CITY OF ALBUQUERQUE

May 19, 2025

**RE: Parking Redesign
2500 Louisiana Blvd. NE
Grading and Drainage Plan
Engineer's Stamp Date: 5/13/25
Hydrology File: H19D095
Case # HYDR-2025-00171**

# GRADING AND DRAINAGE PLAN

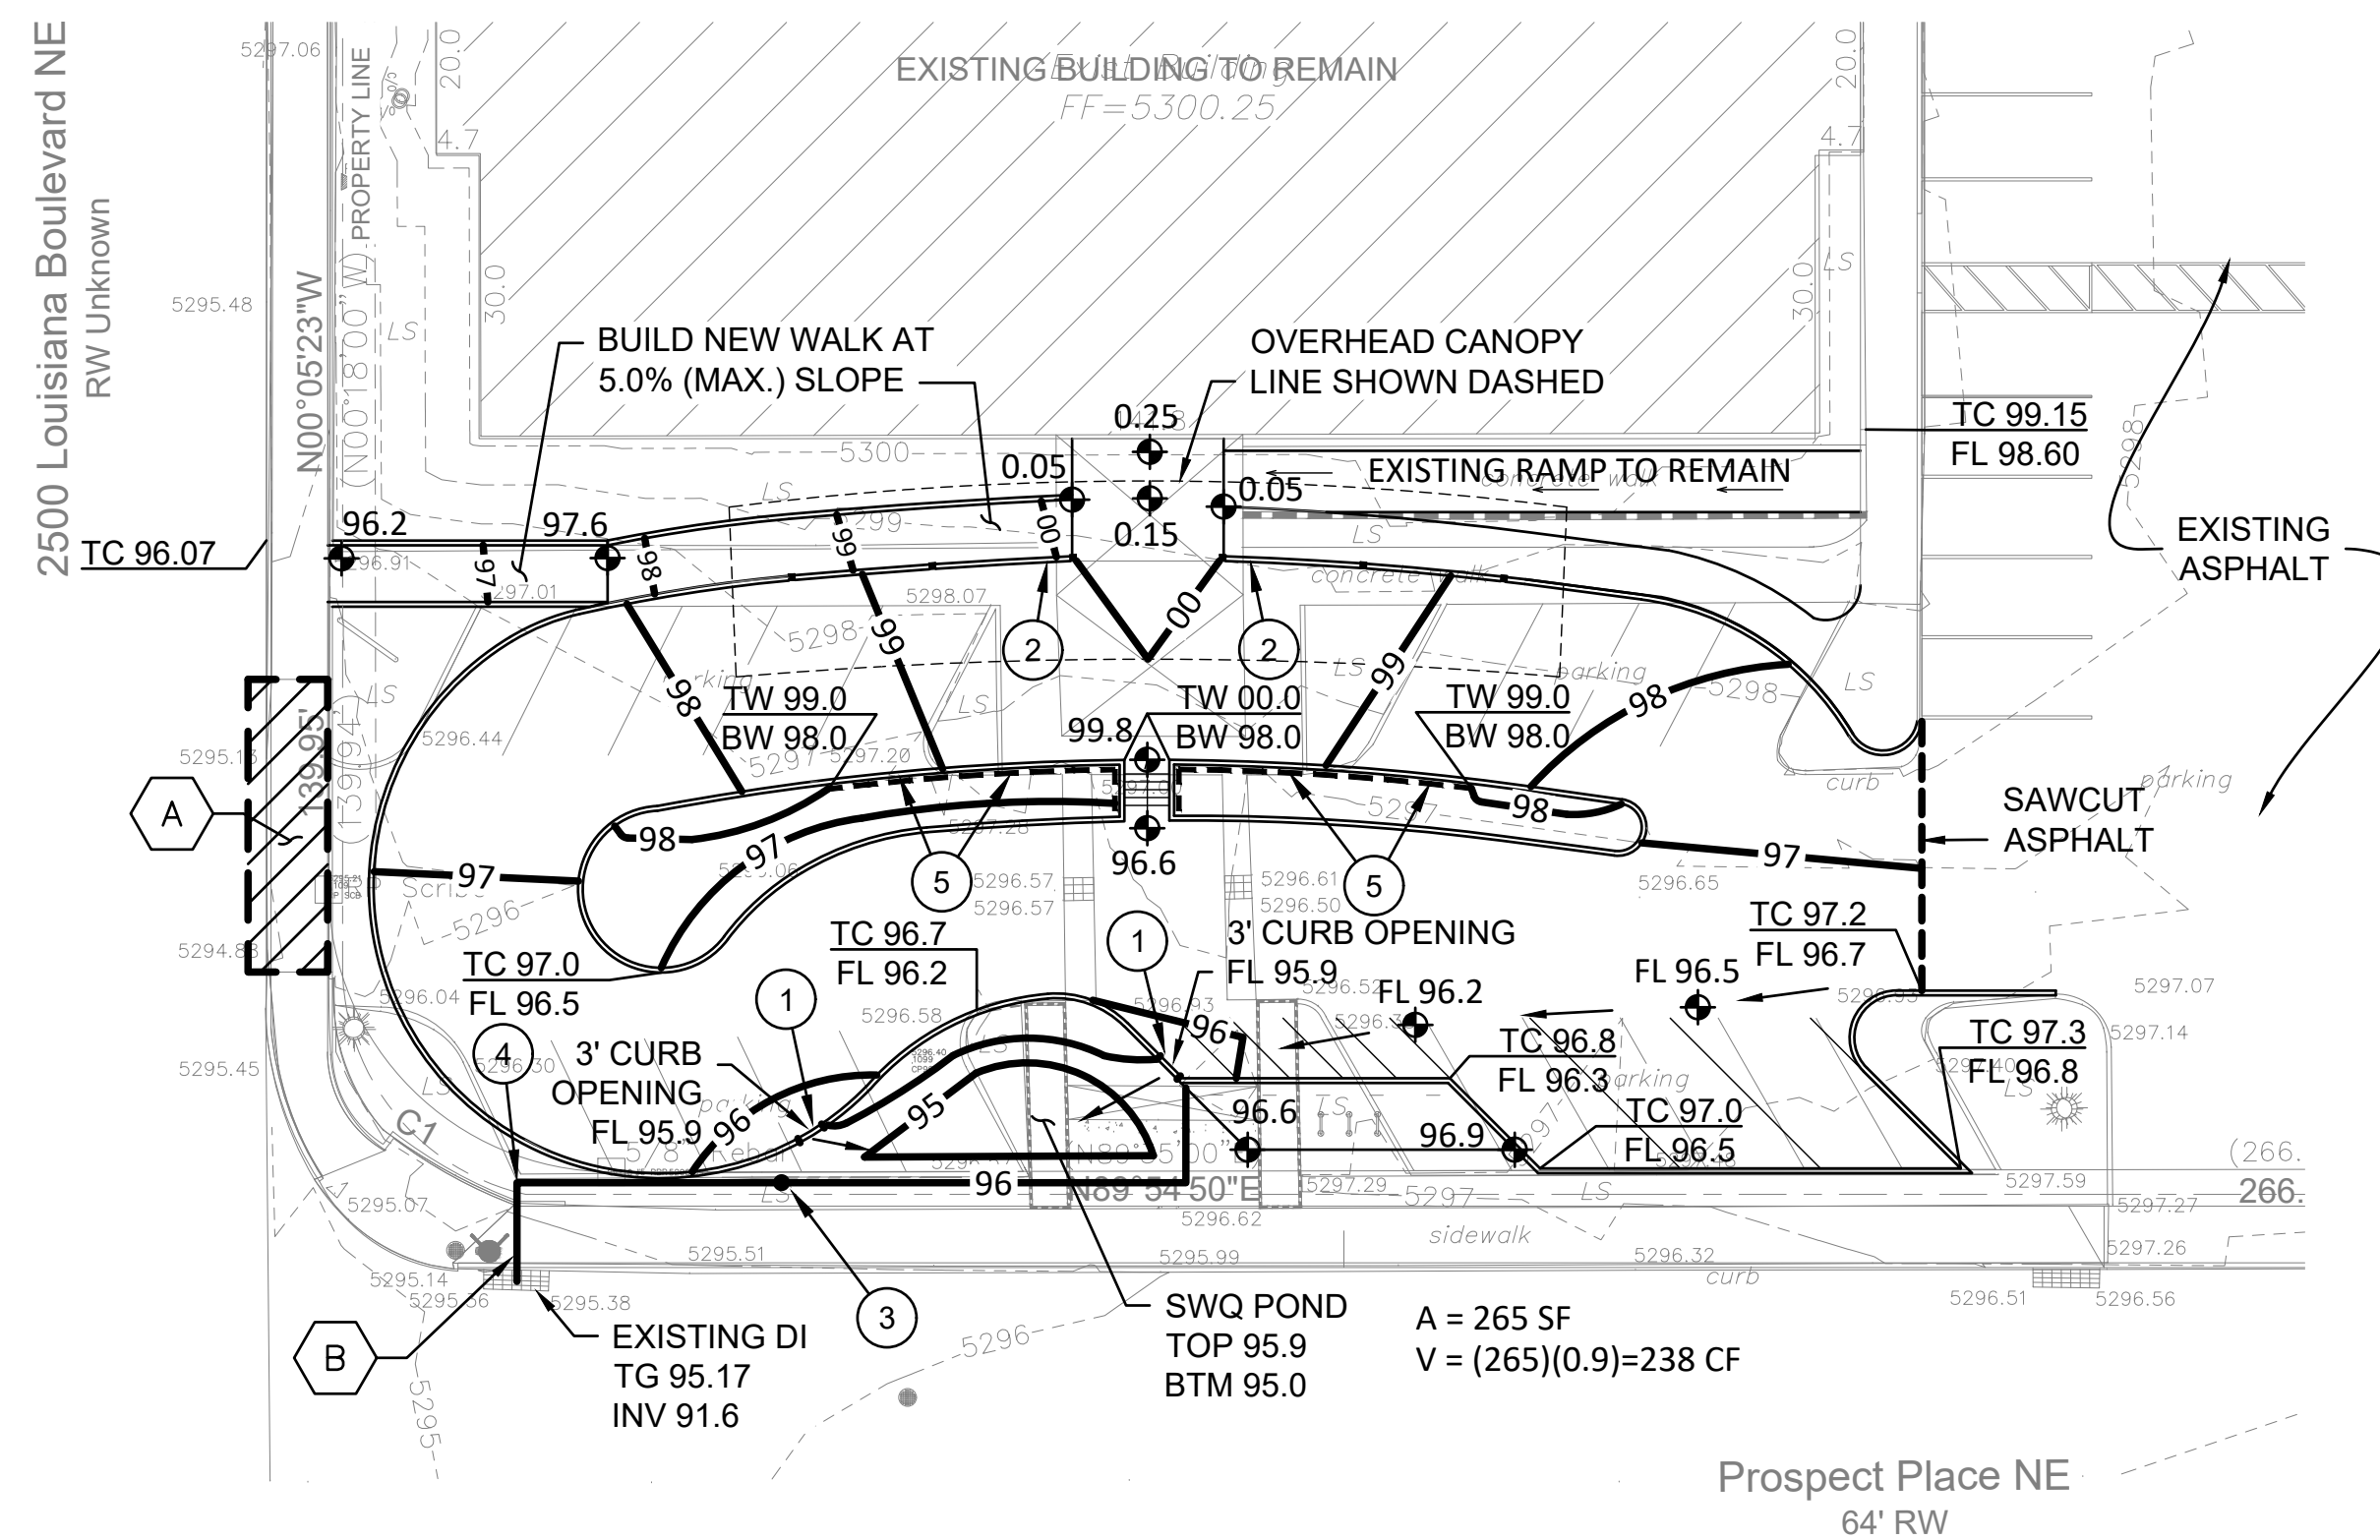
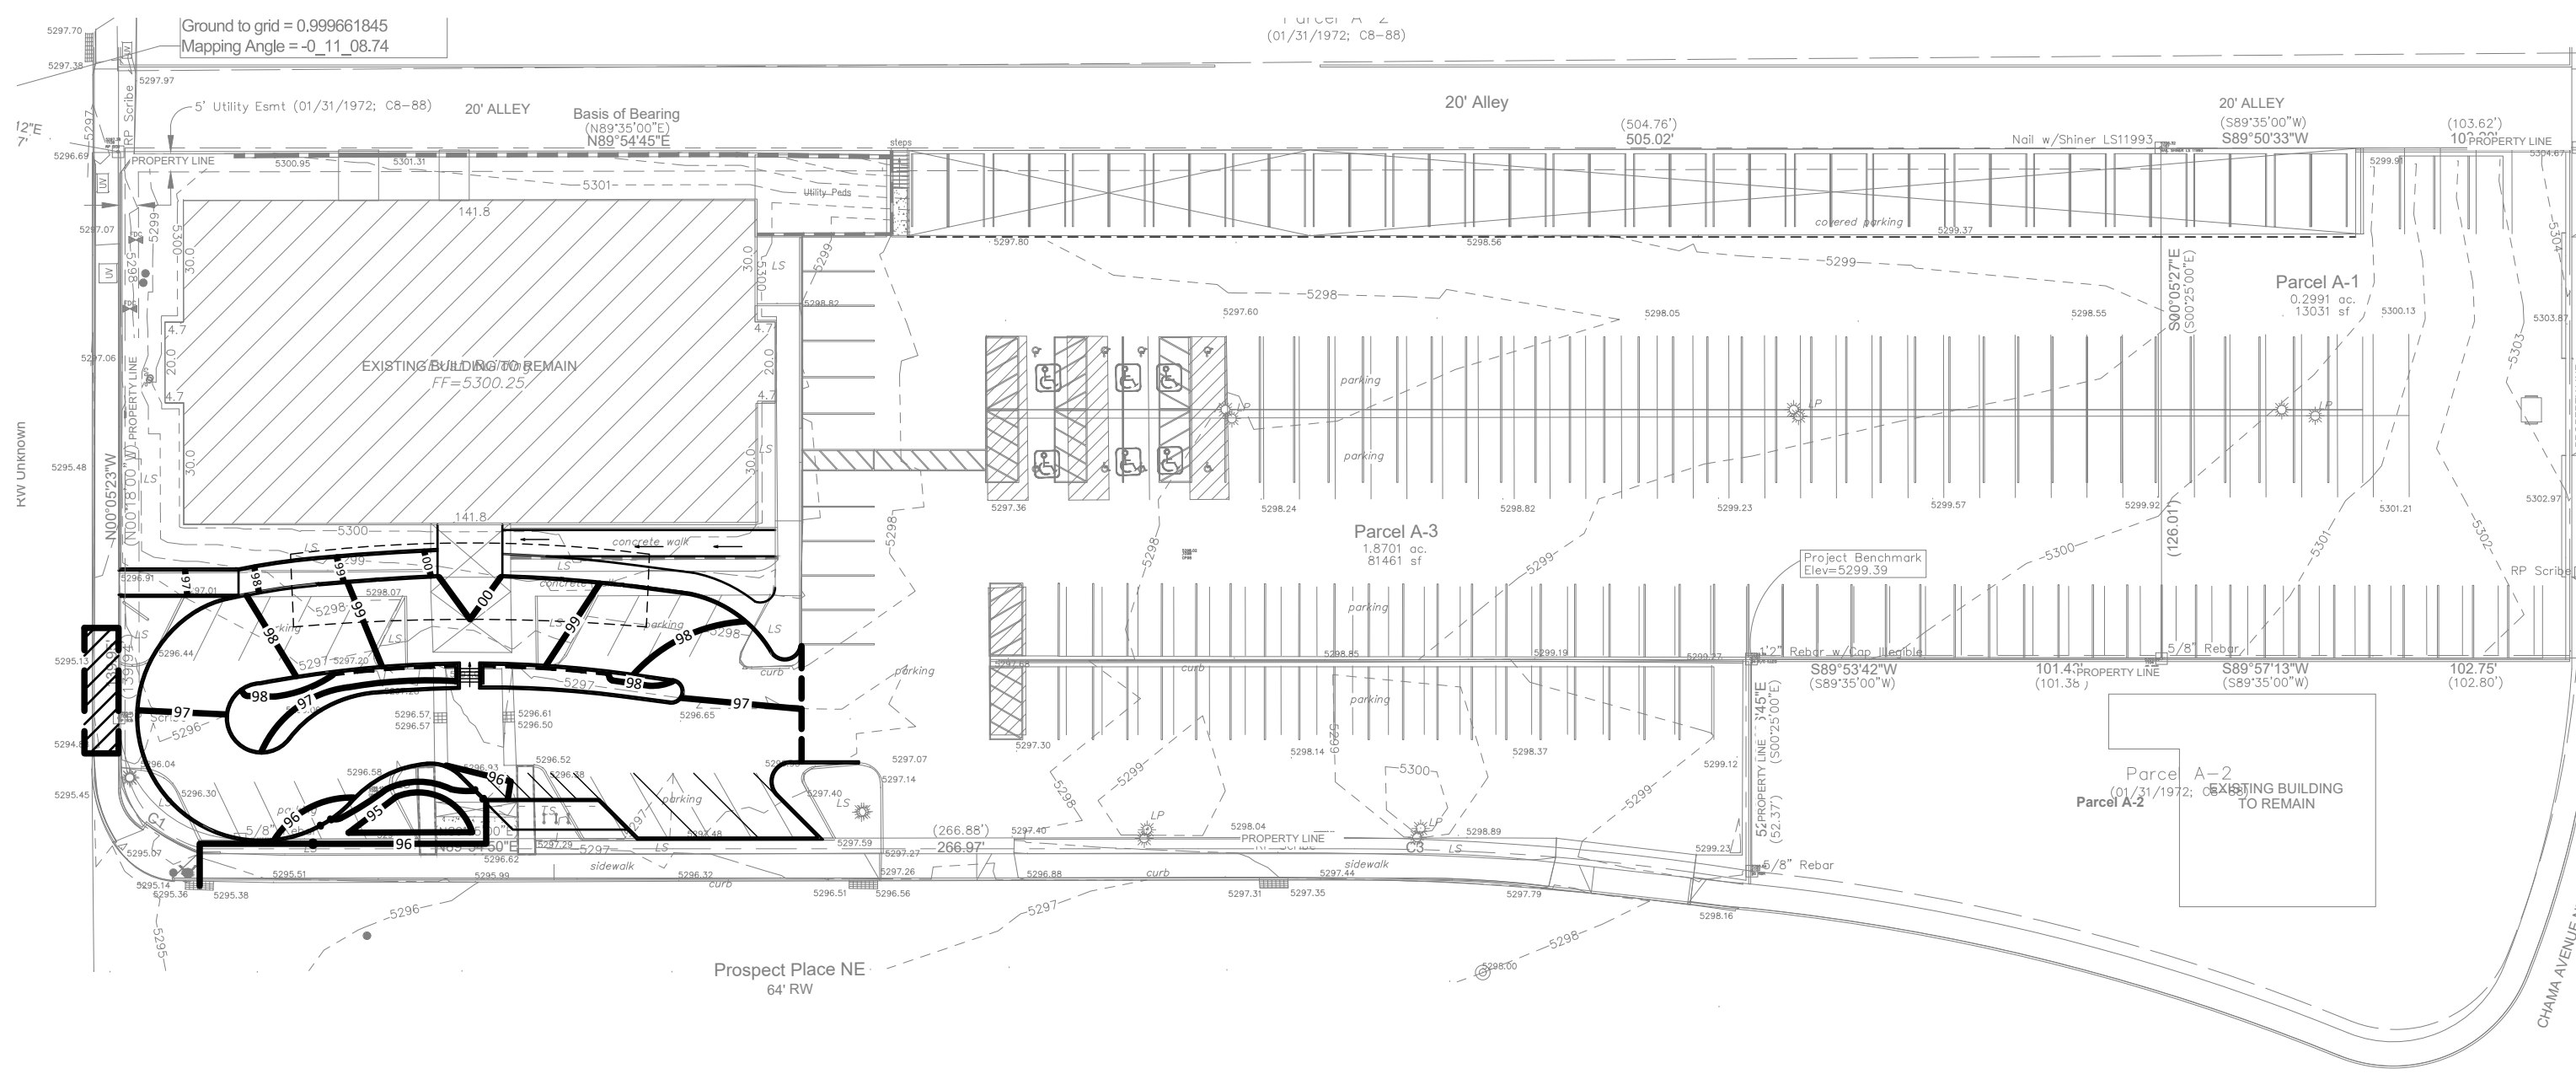
1. Rename the plan as a Grading and Drainage Plan. A Grading and Drainage plan is required for a Paving Permit.
2. Please provide the Benchmark information (location, description and elevation) for the survey contour information provided.

3. Please provide the FIRM Map and floodplain note with effective date.
4. Please provide the legal description of the property.
5. Provide existing and proposed information related to the site area, land treatments, Weighted E, Volume, and Flows per the DPM.

6. This project will be required to either provide SWQV ponds or pay a fee in lieu. The required volumes and fee will be based on the entire site area for redevelopment (0.26") which is much smaller than new development (0.42") per the DPM article 6-12.

7. Provide management onsite for the Stormwater Quality Volume (SWQV) in accordance with the new drainage ordinance, § 14-5-2-6 (H). Please show the top and bottom of the ponds along with the volume for each pond. The onsite drainage should be directed to these

ponds prior to being collected in a private underground drainage system. Please follow the DPM Article 6-12 Stormwater Quality and Low-Impact Development for the sizing calculations. To calculate the required SWQV, multiply the impervious area draining to the BMP by 0.26 inches for redevelopment sites. The calculations of both the required and the provided volume of each BMP must be shown on the Grading and Drainage Plan. Each BMP should be labeled on the Grading and Drainage Plan with the required SWQV and associated water surface elevation and the 100-year water surface elevation. Landscaping of surface BMPs is also required to be noted on the Grading and Drainage Plan.

8. Please provide the SWQV calculations for each basin draining to each pond. The stormwater quality ponds need to be sized for the areas draining to them.
9. If requesting a Waiver of Management Onsite, the following conditions of the new drainage ordinance (enacted 10/2/18) must be demonstrated on the plan (§ 14-5-2-6 (H)):

10. Please show the Payment in Lieu calculation on the plan.
11. Please add a note which states, "The Owner has elected to pay the Payment in Lieu for the required Stormwater Quality Volume."
12. Please add a note under Grading Notes. "Side slopes need to be stabilized with Native Grass Seed (per City Spec 1012) with Aggregate Mulch or equal (Must satisfy the "Final Stabilization criteria" CGP 2.2.14.b.)".
13. Please provide the Drainage Covenant with Exhibit A for the stormwater quality ponds per Article 6-15(C) of the DPM. Please submit the original copies along with the **\$ 25.00** recording fee check made payable to Bernalillo County to the Hydrology Section of Development Review Services on the Ground floor of Plaza de Sol
